**KIRKLEES METROPOLITAN COUNCIL
INVESTMENT & REGENERATION SERVICE**

Reference No:	2022/62/93557/E
Site Address:	82, Wakefield Road, Clayton West, Huddersfield, HD8 9NN
Description:	Erection of raised deck
Recommending Officer:	Jennifer Booth

OFFICER REPORT

A SECTION A AS PROPOSED
1:50

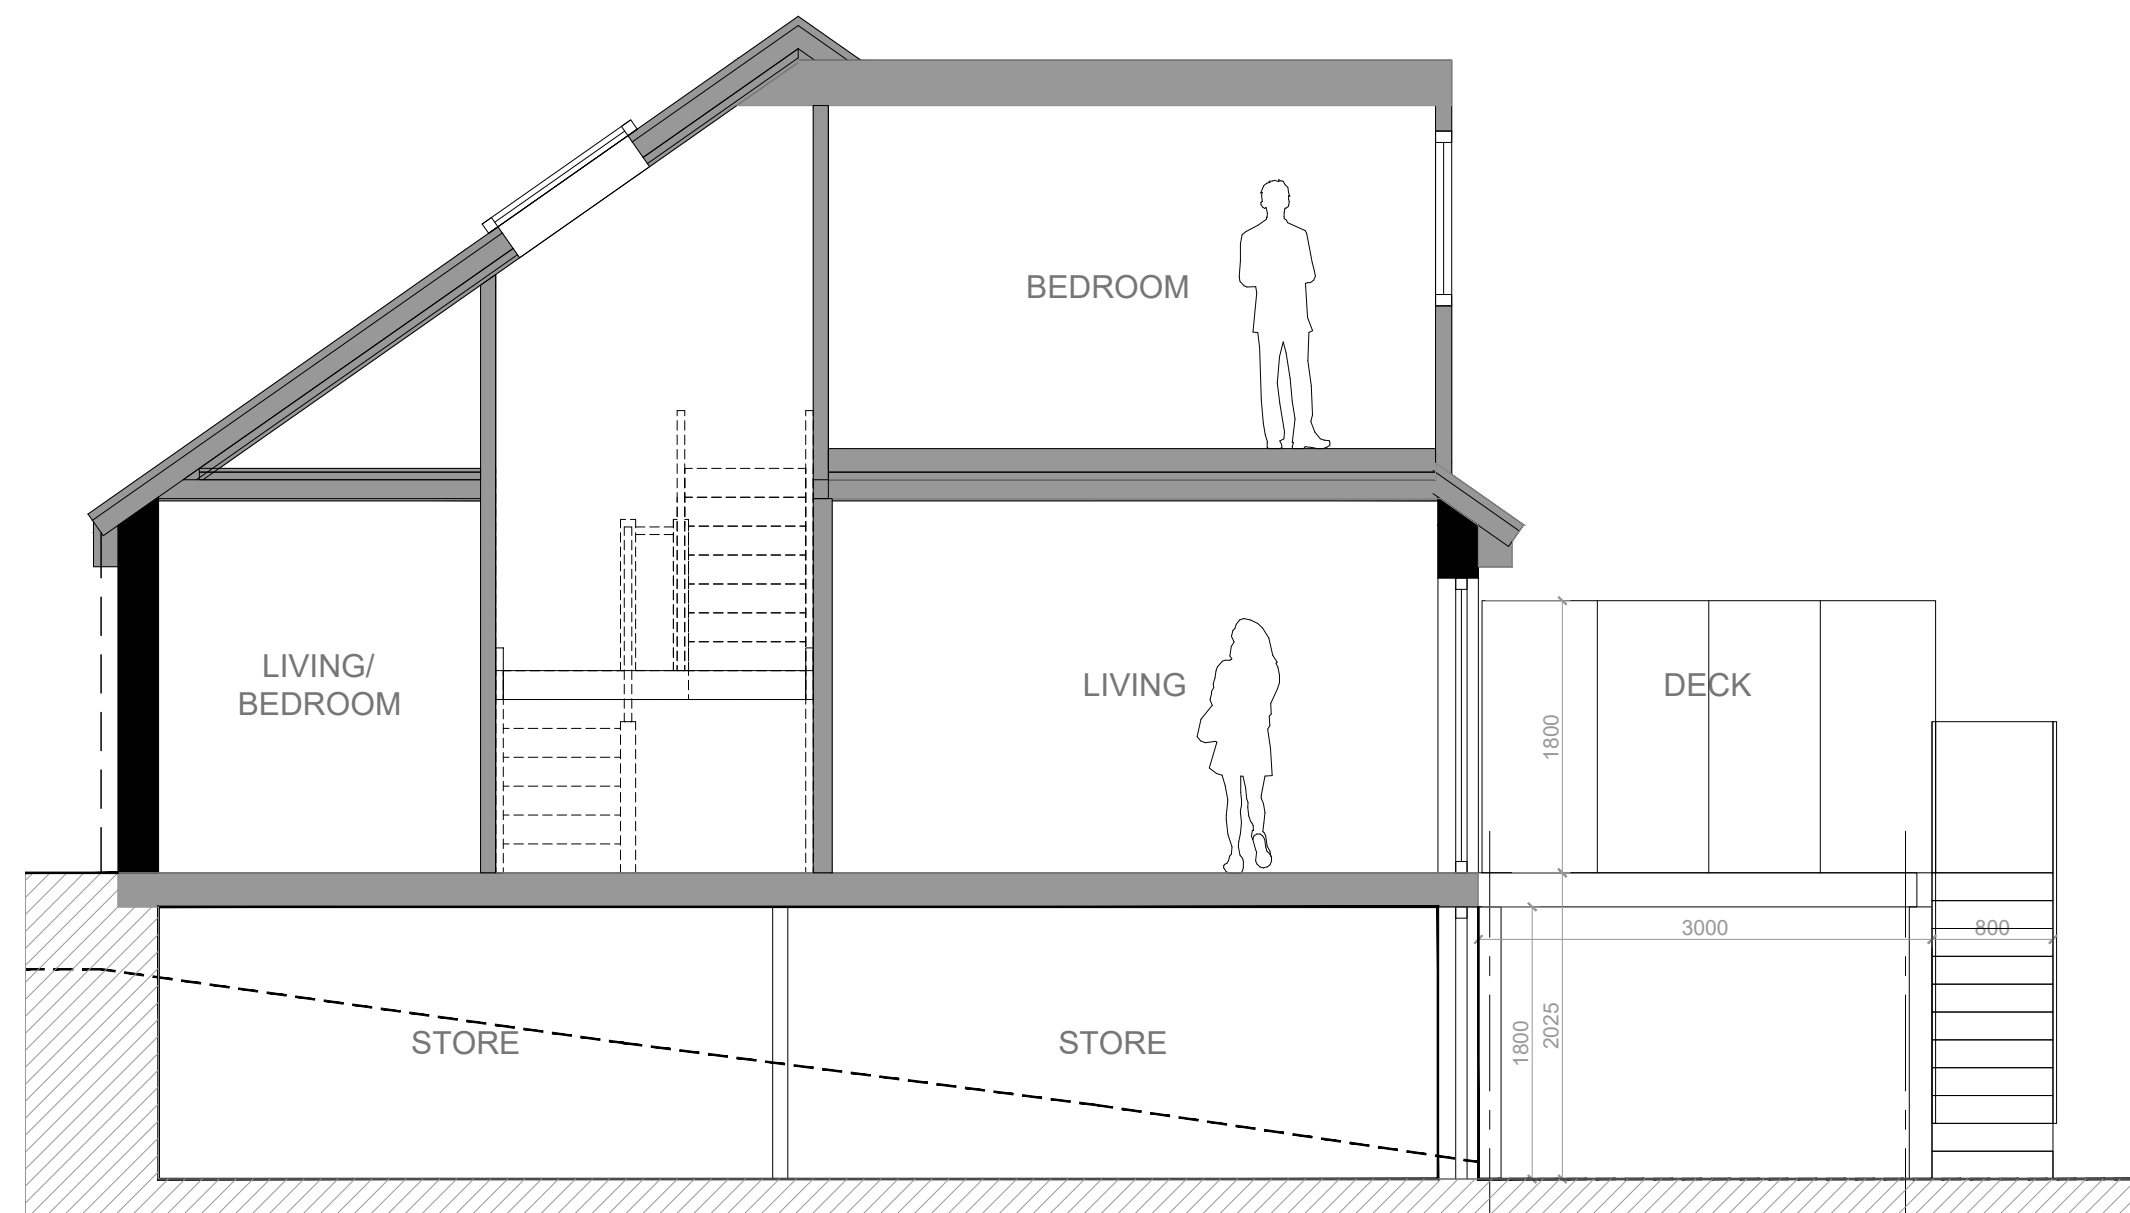
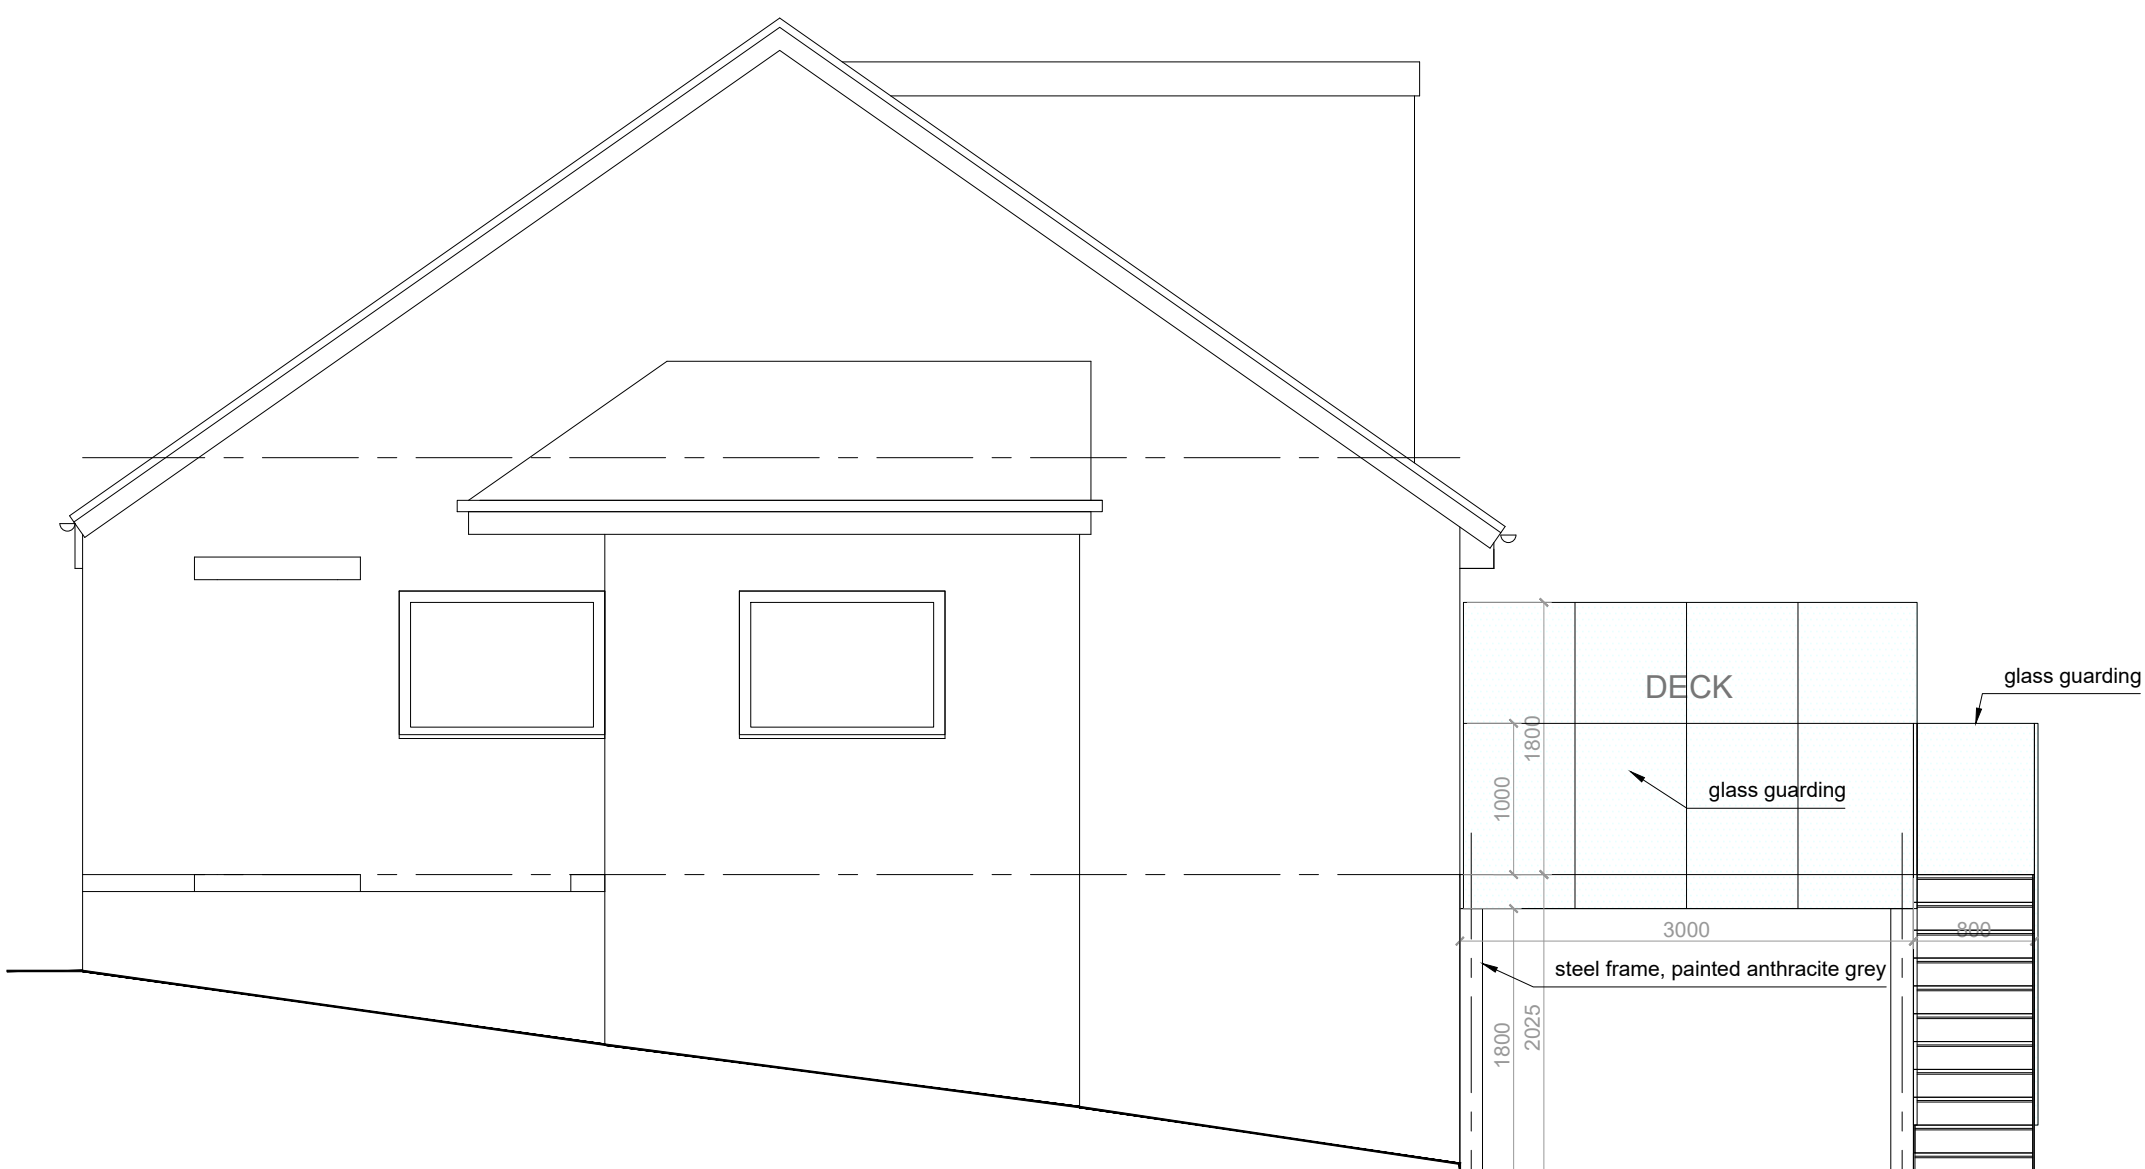
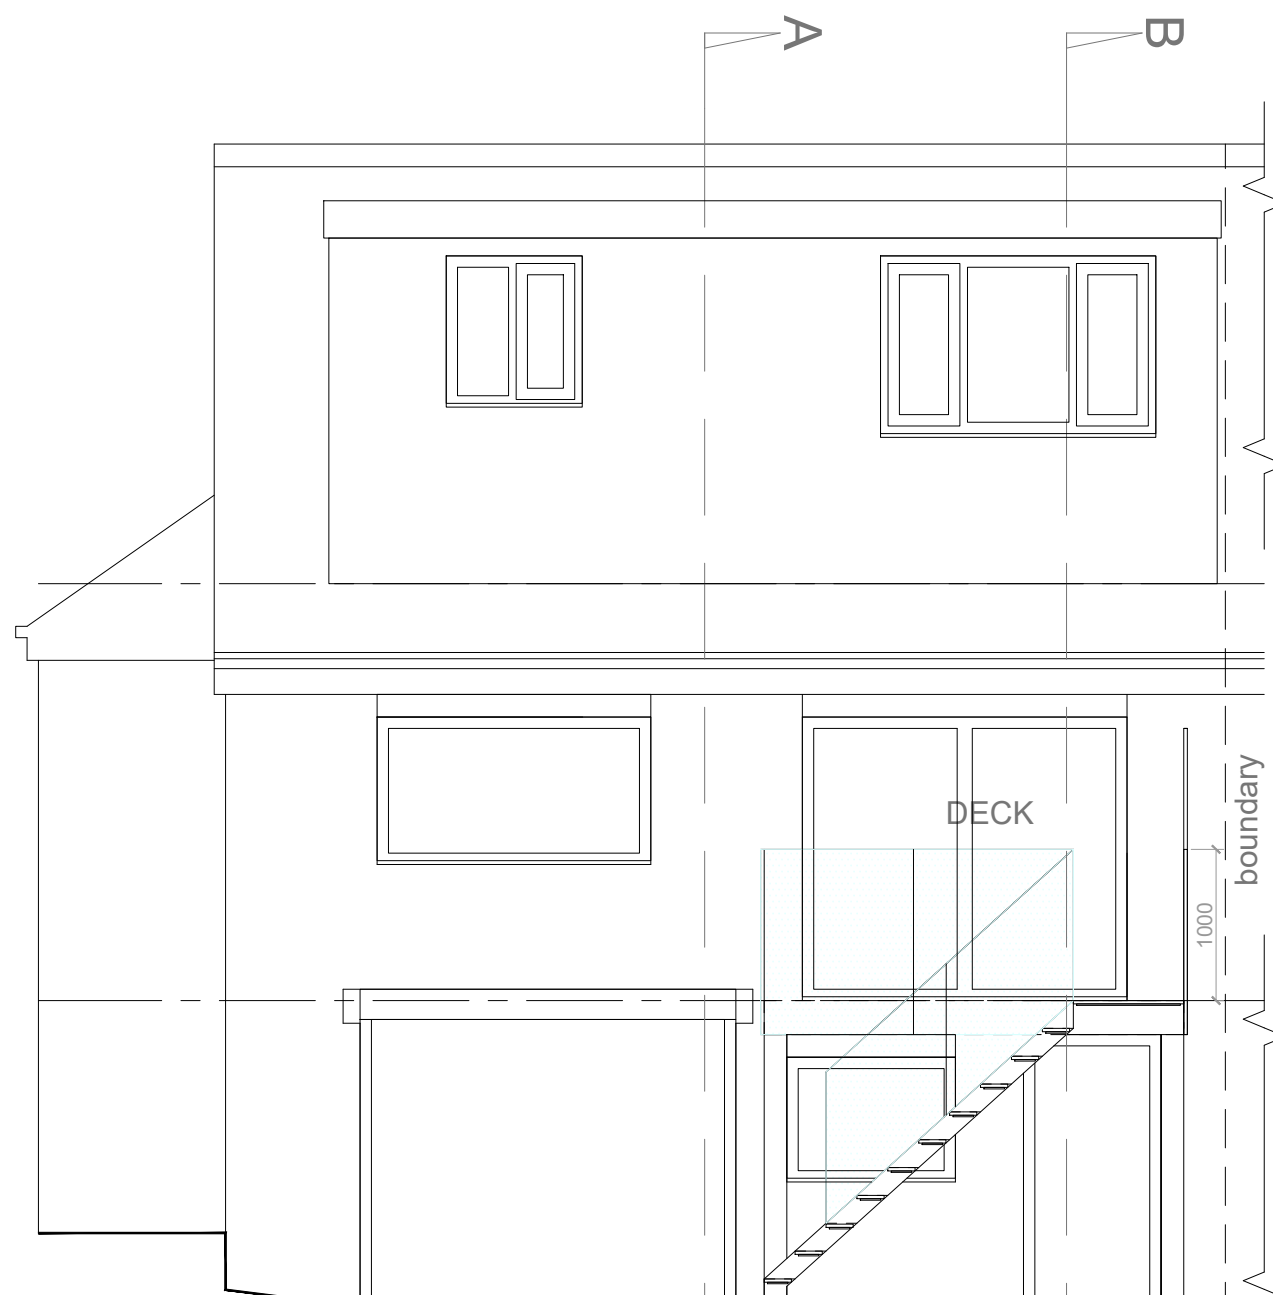
The platform of the raised decking would be 1.8m above the ground level with a projection of 3m, a width of 2.8m and an additional 0.9m for the stairs. The balcony would be enclosed with a 1.8m high glazed screen.

The balcony will be constructed using steel supports and beams, with a balcony floor structure, staircase, glass balustrade and obscurely glazed privacy screen along the boundary with the adjoining house. Although these construction materials do not match the existing dwelling, it is considered that they are acceptable, given that the materials will allow the structure to have a lightweight and unobtrusive appearance. In addition, these materials are common for this type of proposal, with the privacy screens welcomed from a residential amenity perspective.

The balcony would be constructed along the shared boundary with the adjoining property. To prevent overlooking, screening has been included. Given the materials proposed that will allow light to penetrate through, the limited projection, the screening would not result in any significant overbearing or overshadowing. The height and positioning of the screening proposed will prevent the potential for a loss of privacy in any of the rooms to the rear as a consequence of looking back towards the rear elevation of the neighbouring dwelling from the deck. A condition regarding the screening is imposed to ensure it is retained at a sufficient level in the position shown in perpetuity.

3. The privacy screen shown along the south western side of the deck/balcony, hereby approved, shall be maintained at 1.8 metres and shall be obscurely glazed to a minimum privacy level 4 or equivalent and shall thereafter be retained.
